FW: SUB19-002 (SEP19-005/Requirement For No Onsite Open Space/Lack of Tree Regulation

Subject: Re: SUB19-002 (SEP19-005/Requirement For No Onsite Open Space/Lack of Tree Regulation

This is a summary of the objections I plan to make to the hearing examiner on this project and is a reply post on ND.

2825 W MERCER WAY

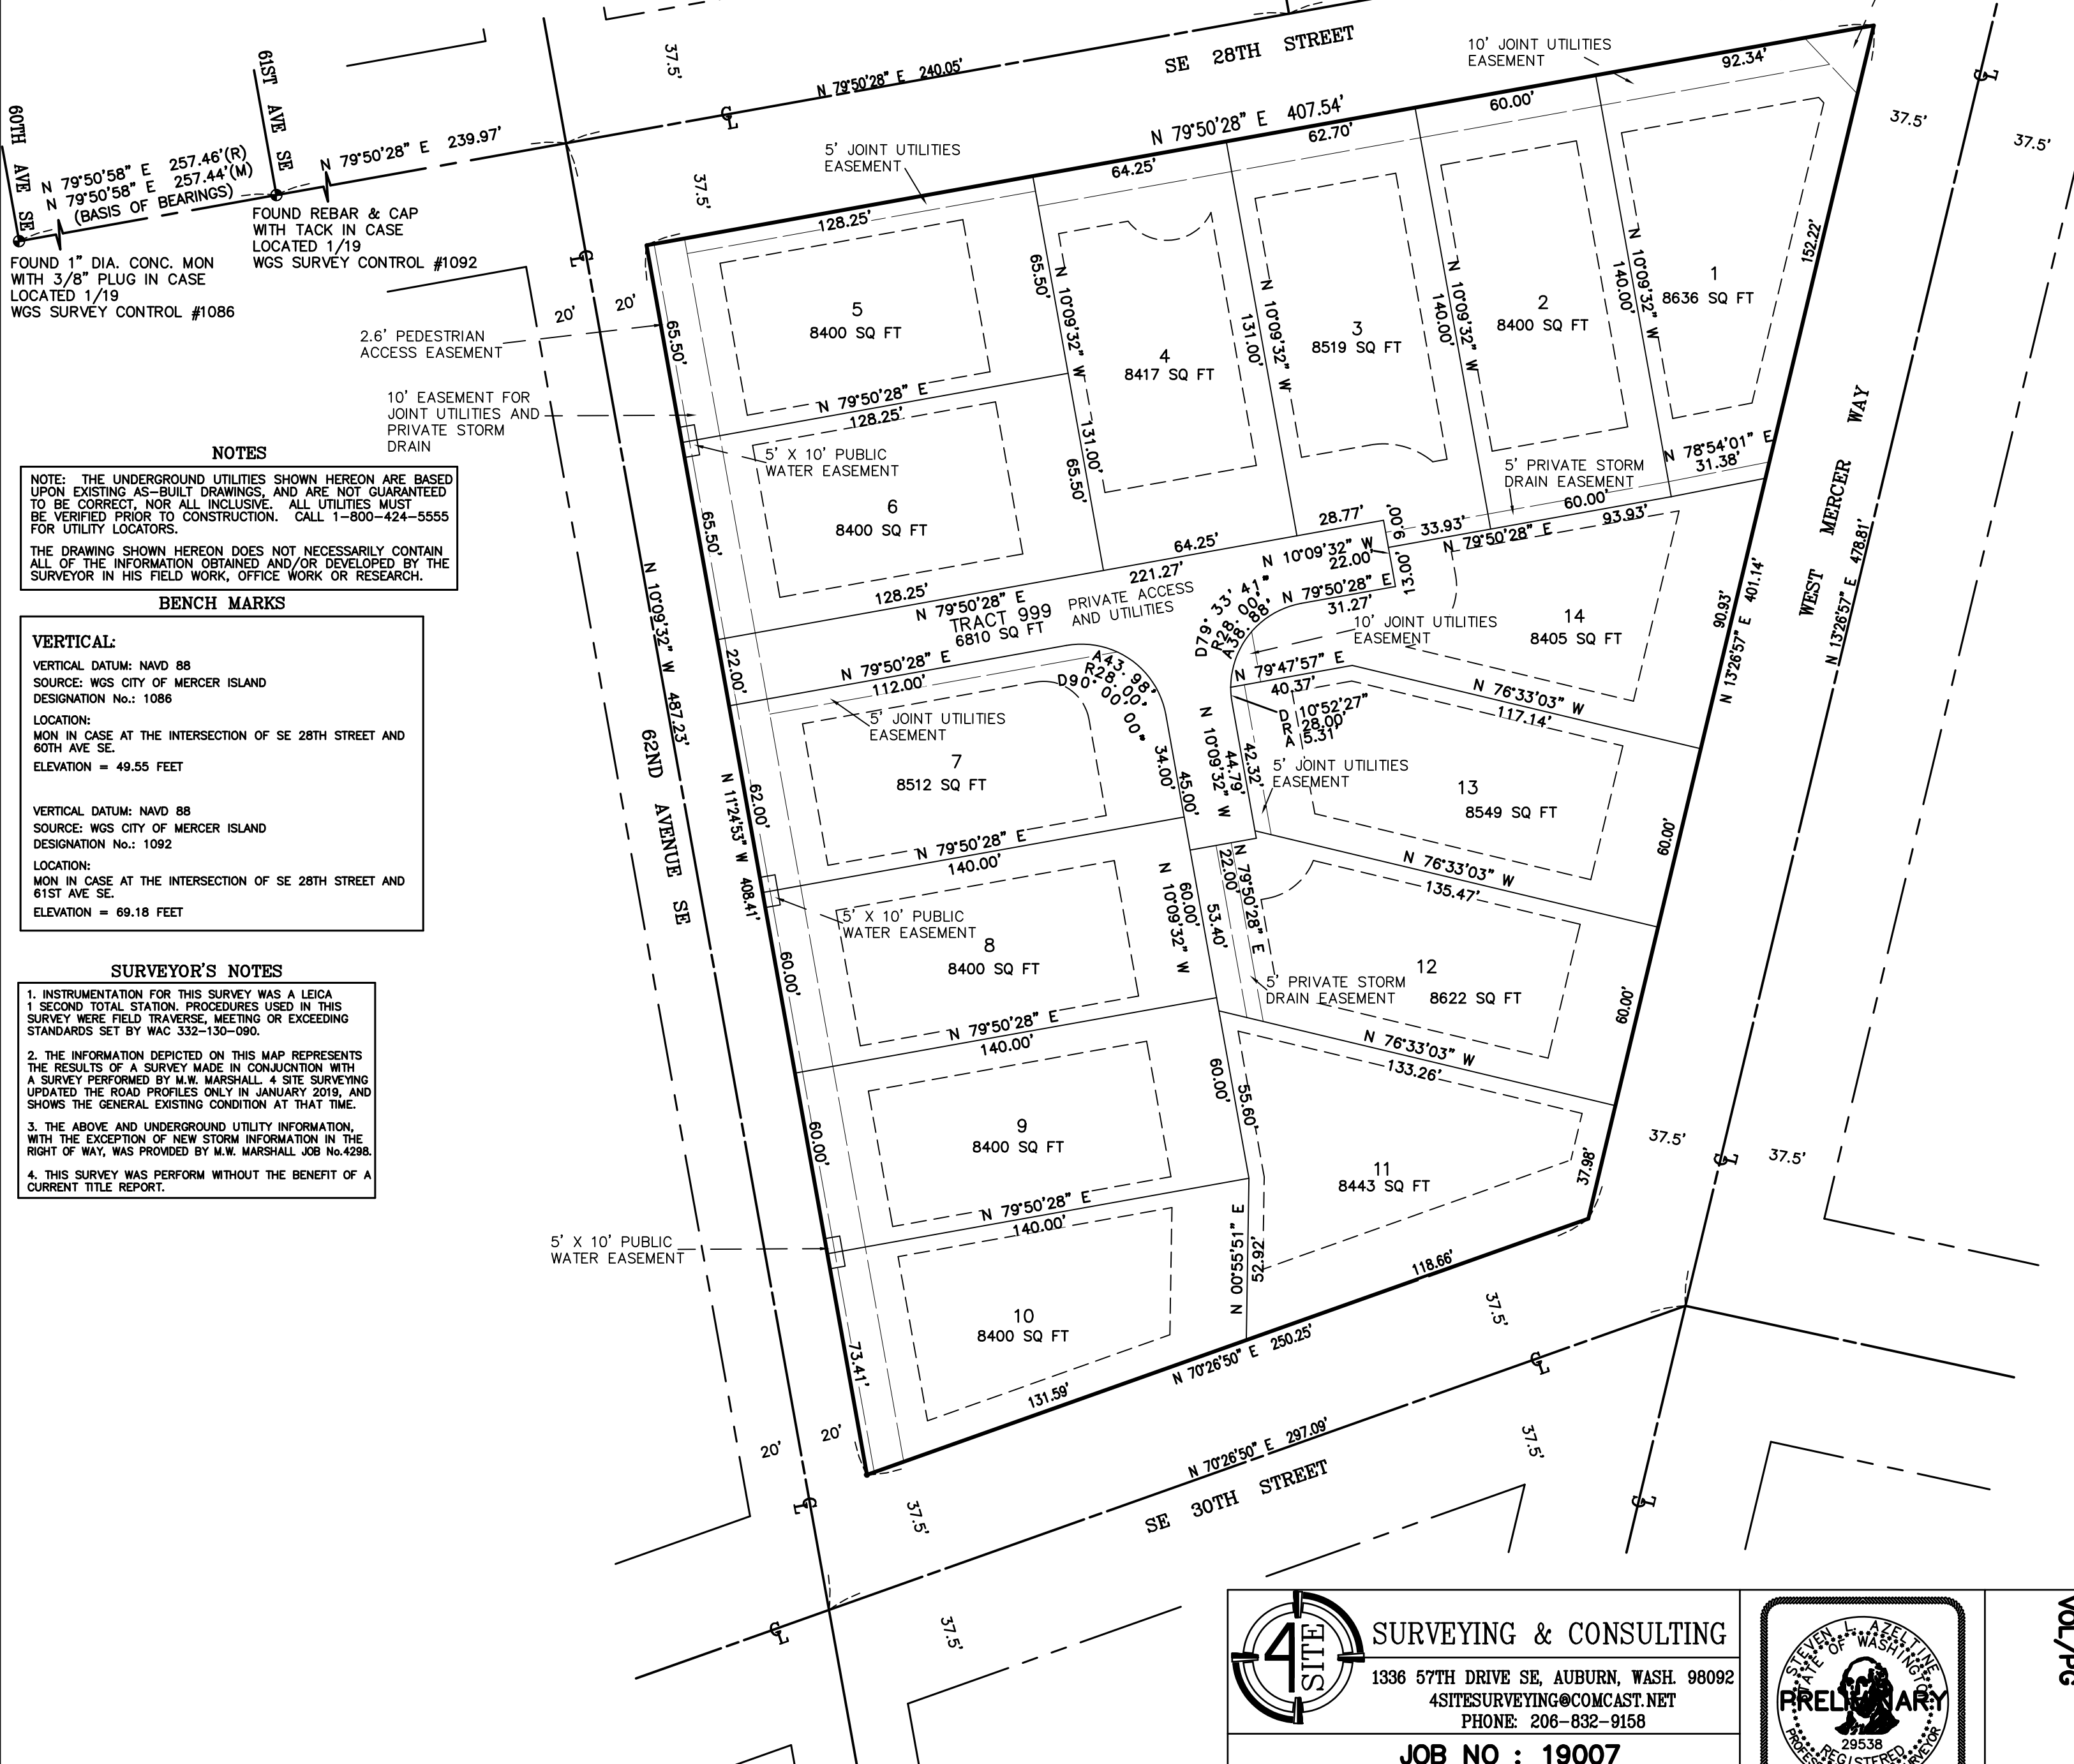
Here is a site map for the proposed 14 plat long division. [12. pin2174502425-supplplatmap.pdf \(mercergov.org\)](#). The only "open space easement" listed on the map is the tiny triangle in the upper right-hand corner.

PRIVATE OPEN SPACE EASEMENT

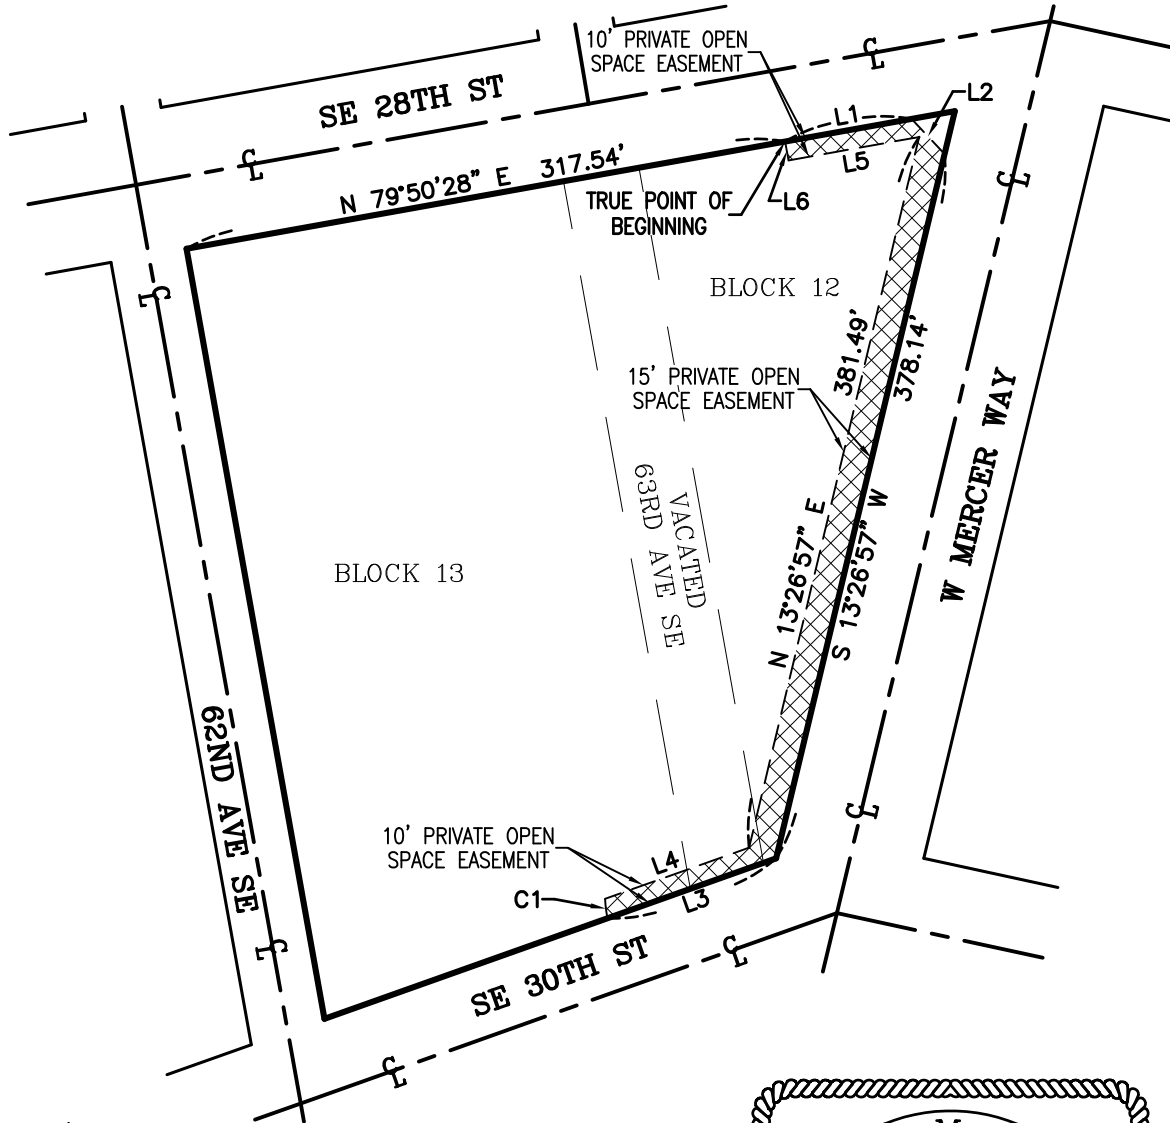
"Staff Finding: The proposed development makes a provision for open spaces in the form of a private easement for passive open space (Exhibit 5). The MICC does not provide a numerical standard with respect to the level of appropriateness as to the provision of open space".

I have never heard of something so absurd. The applicant's "open space" is based on an existing city park accessed by the required setback. Because the planner claims that, *"The MICC does not provide a numerical standard with respect to the level of appropriateness as to the provision of open space"* the planner interprets this to mean zero open space without addressing the requirements under R.C.W. 58.17.020. **Is Jeff Thomas really rewriting state law and the MICC to hold a 14-lot long plat requires no onsite open space, or this is the intent of 19.08? Is Jeff unaware of the Coval long plat?**
